Your Ref: OWPC18967
Our Ref: BR/229/17/PL 11-08-2017
Please ask for:
Mr S Davis

Erection of 3 No. dwellings, 1 No. detached garage, parking & alterations to existing access & driveway (resubmission following BR/200/16/PL).

Land to rear of 41 - 47 Pevensey Road Bognor Regis

Thank you for your internet representation made on 25th June 2018 which has been recorded as '**an objection**' with the comments as follows:

DRAWING TITLE	
Block & Location Plans and Site Section	
DATE	SCALE
Feb 18	1:200 @ A1
JOB NO.	DRAWING NO.
1615	2.13
	CHECKED BY
	REVISION
	DRAWN BY
	GIM

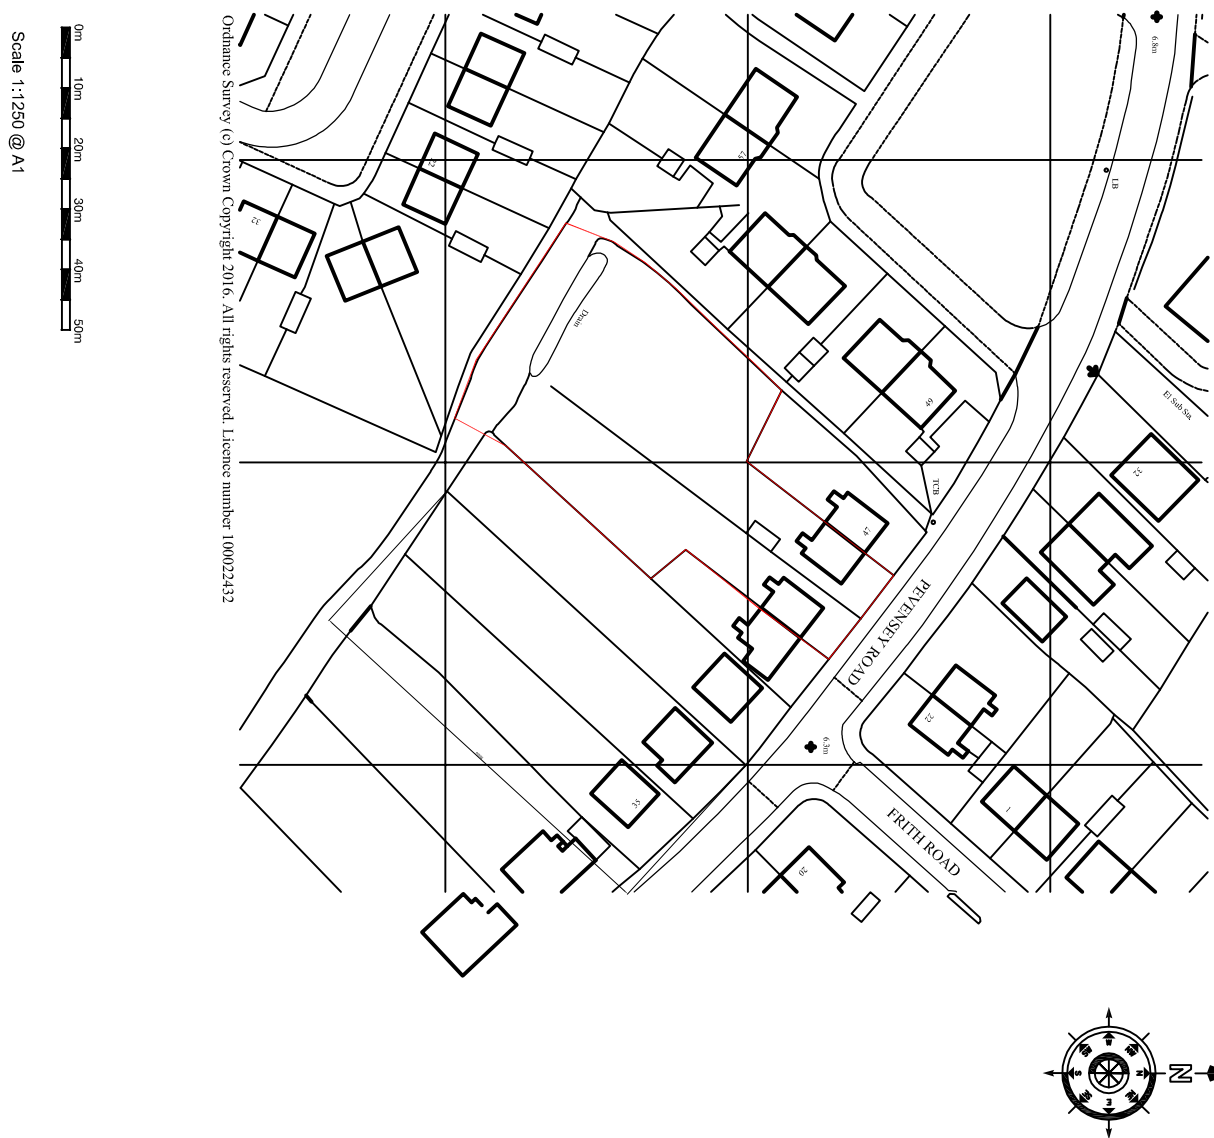
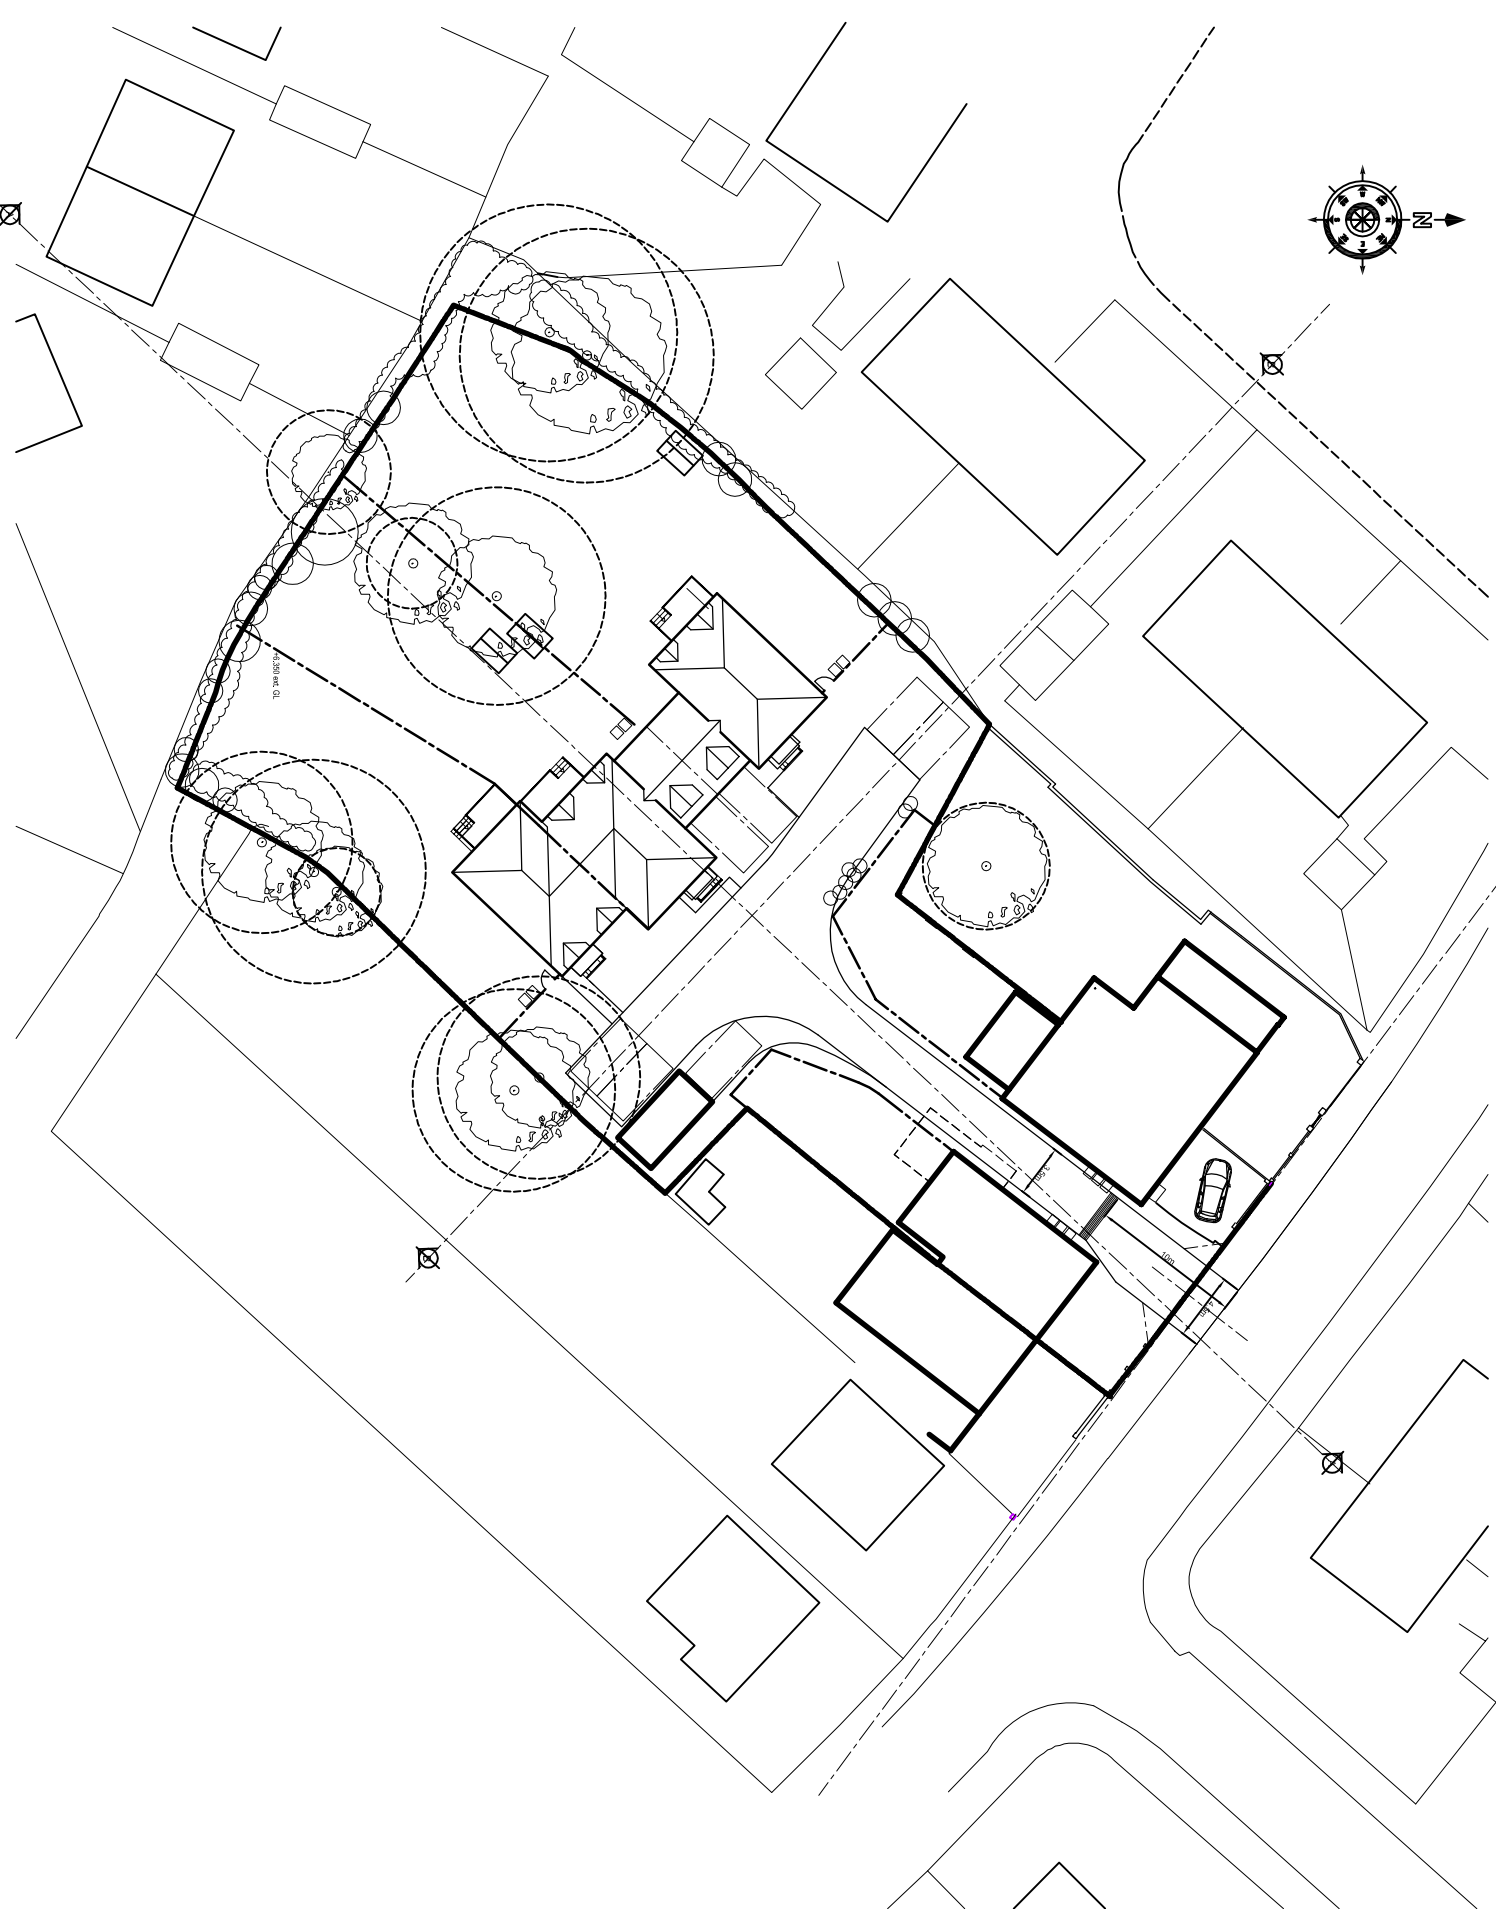
1 The proposed new access road into the new development site is too close to the existing junction of Pevensey Road and Frith Road. Although both are in the 20 mph low speed zone the 20 mph speed limit is not observed by the majority of drivers, nor is it enforced. Parking too close to corners and on the footpaths is a daily occurrence in Pevensey Road and Frith Road, particularly by drivers of commercial vehicles who are also residents. There are many elderly and infirm users of mobility scooters who experience enough difficulty negotiating their way around the afore-mentioned obstacles and street junctions already without adding more. There are many young mums trying to walk their very young children to school pushing prams along ever narrowing footpaths and trying to cross roads in heavy, fast-moving traffic. This traffic has a habit of stopping on footpaths to unload children who then have to try to cross those same roads. This, of course, happens in reverse at the end of the school day.

There are many elderly and frail residents who attempt to walk along Pevensey Road and Frith Road to go shopping, catch buses, etc. who do not need another road crossing to negotiate. Fire appliances and other similar-sized vehicles will have difficulty accessing the new houses.

Inevitably those new houses will be occupied by families with young children who will be in danger every time they play outdoors or go to school, ride their bicycles, etc. The proposal to use the two very narrow footpaths lining the new access to the proposed development as refuse and recycling collection points will force pedestrians to walk on the road. This is unacceptable.

The site layout plan shows turning provision for a Fire appliance which is unlikely to be available in reality due to parking of multiple vehicles for each house and visitors parking at each of the houses at the same time.
